From: [REDACTED]
To: [Mona Offshore Wind Project](#)
Subject: EN010137
Date: 30 September 2024 22:35:57

IP ref: 20048555

Re ExQ1 Q1.8.2

Figure 1.5: Surface watercourses and NRW flood zones within the Mona hydrology and flood risk study area (sheet 3)

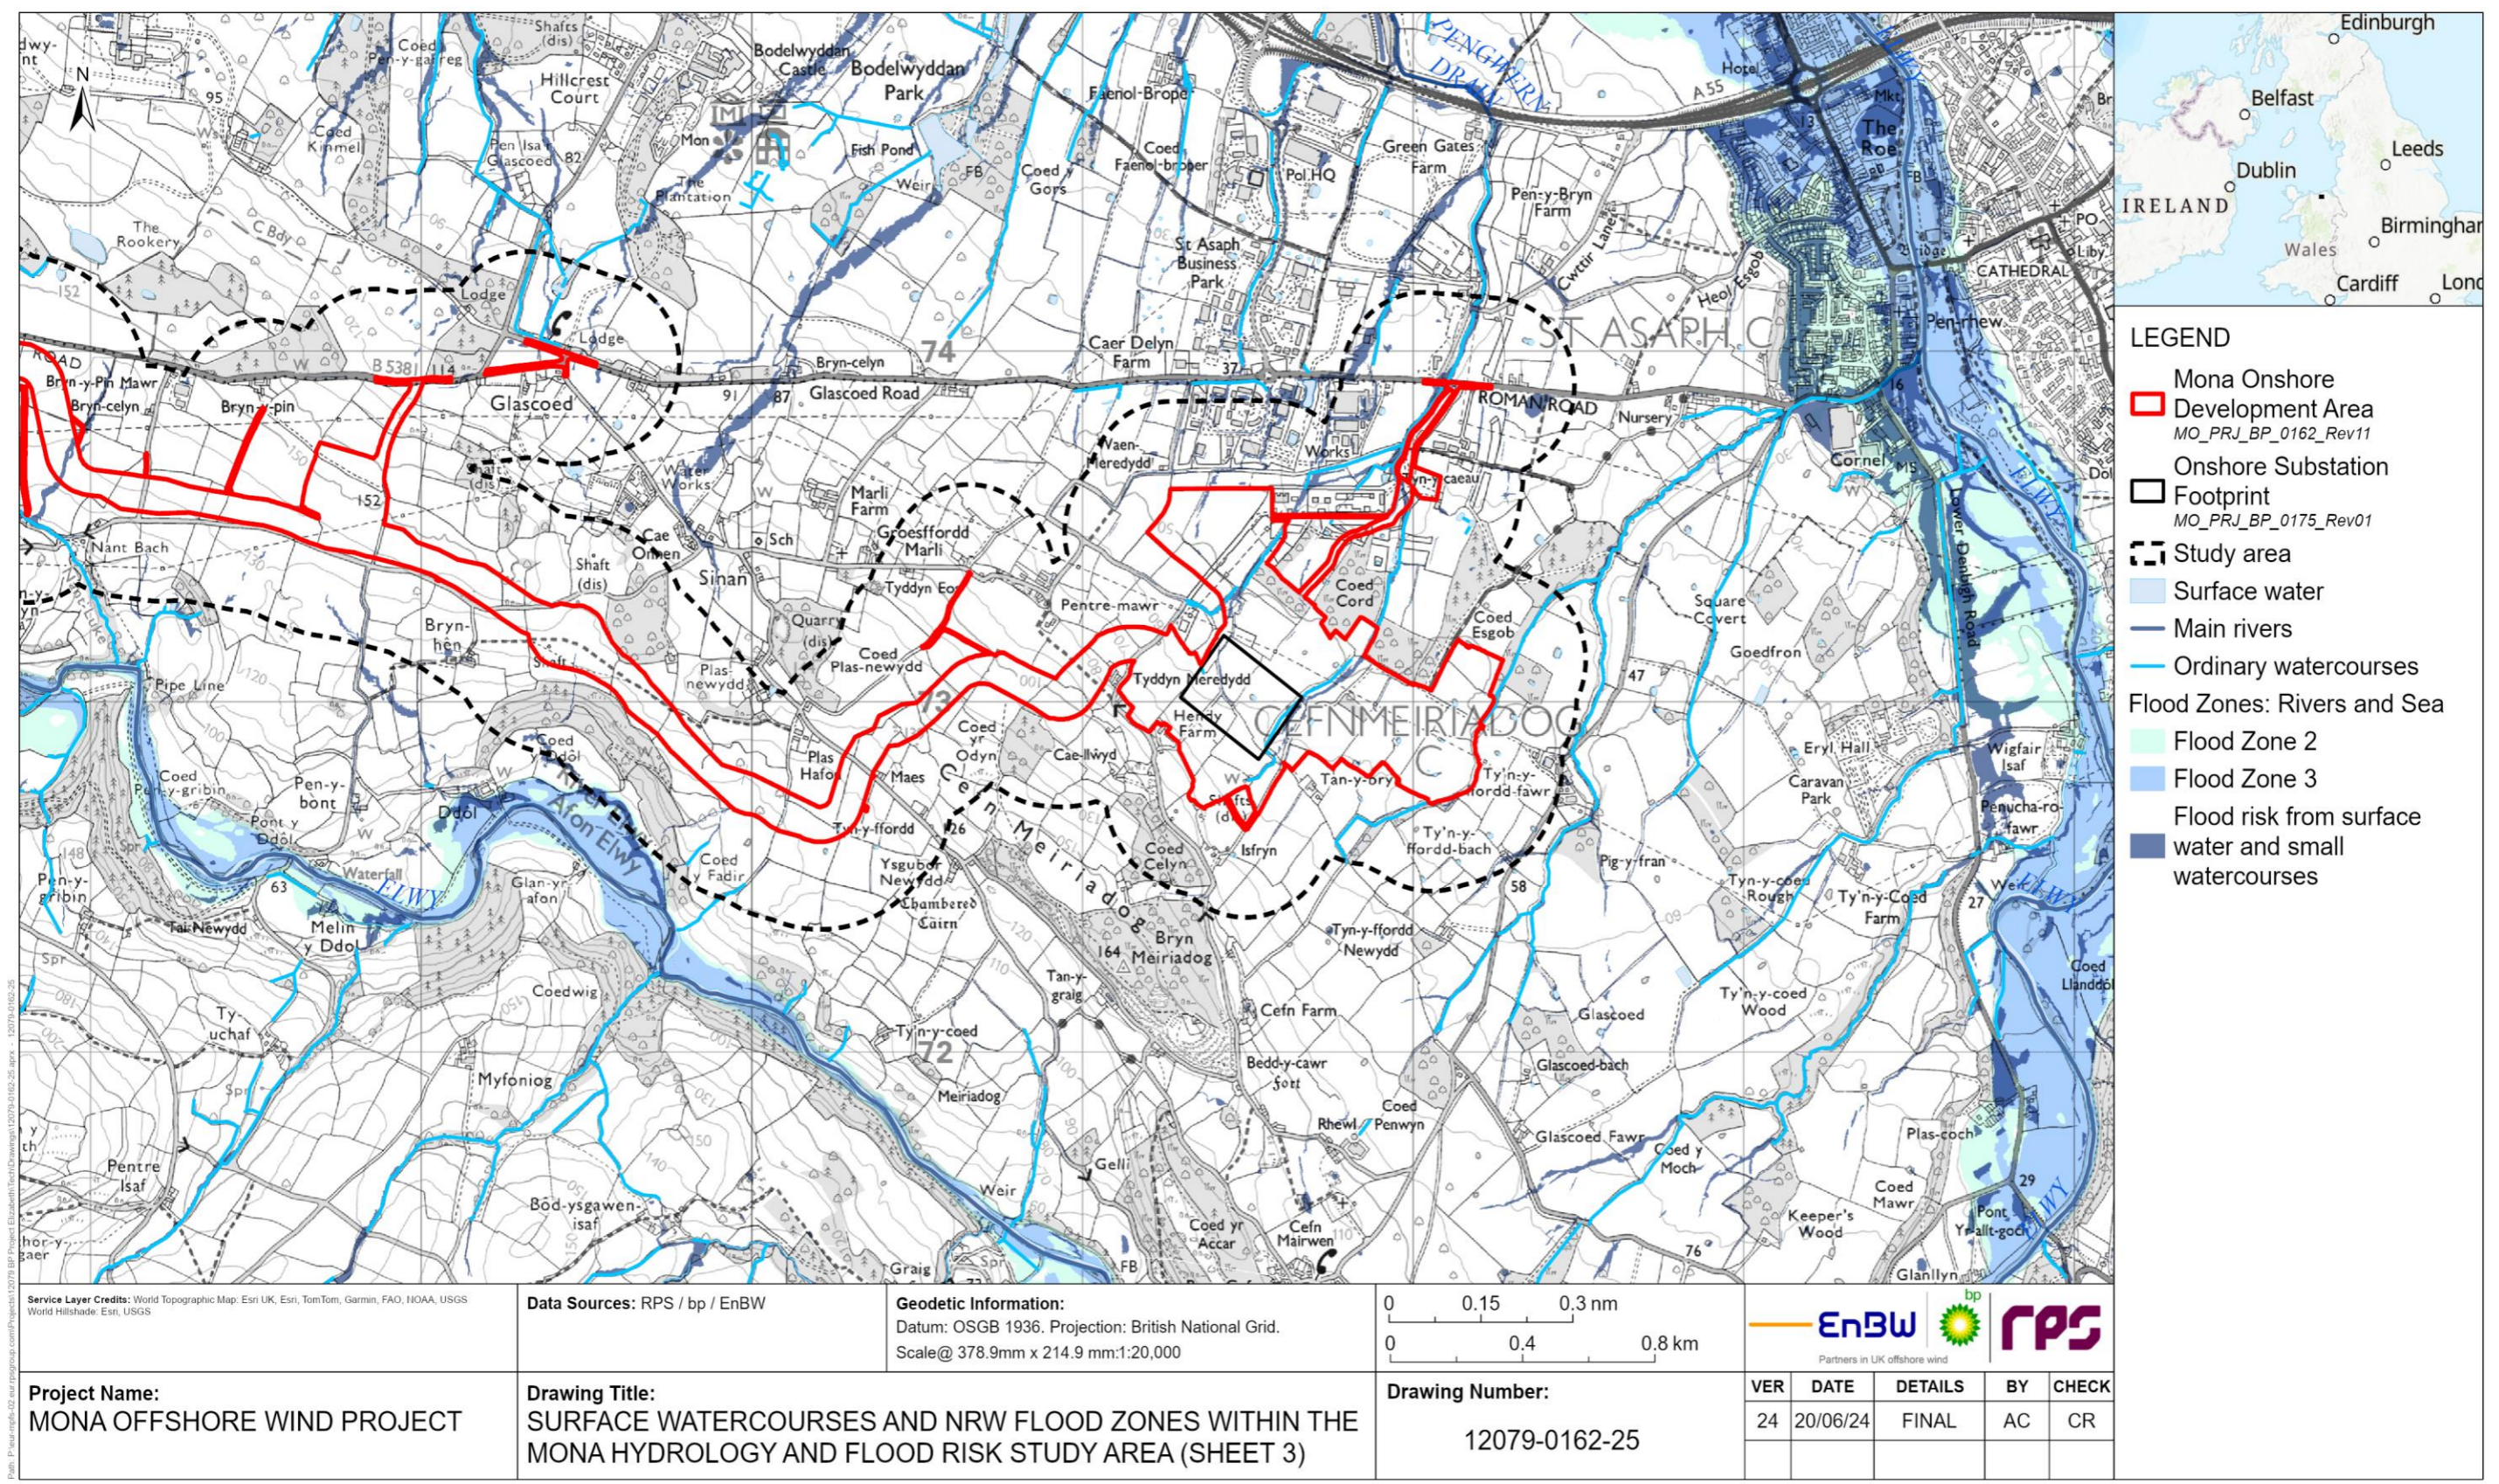
In answer to the exa's question regarding watercourses and flooding in the area of tcc2, has the applicant addressed my concerns? The answer is no.

The applicant's response has been to direct me back to their existing application documentation, which i have already made clear lacks any detail and has significant abnormalities, that makes looking at it again useless.

The document suggested makes no mention of the fact that if they are permitted to drill their cable where they sometimes say they want to (but at other points they indicate a different track) they will alter the location of the head of a river. It is impossible to predict the new location of a spring once its track has been disturbed at depth. The river issuing from the spring that i am talking about does not even feature on the applicants mapping. So their conclusion that damaging it will be negligible, when they don't even acknowledge its existence is baffling.
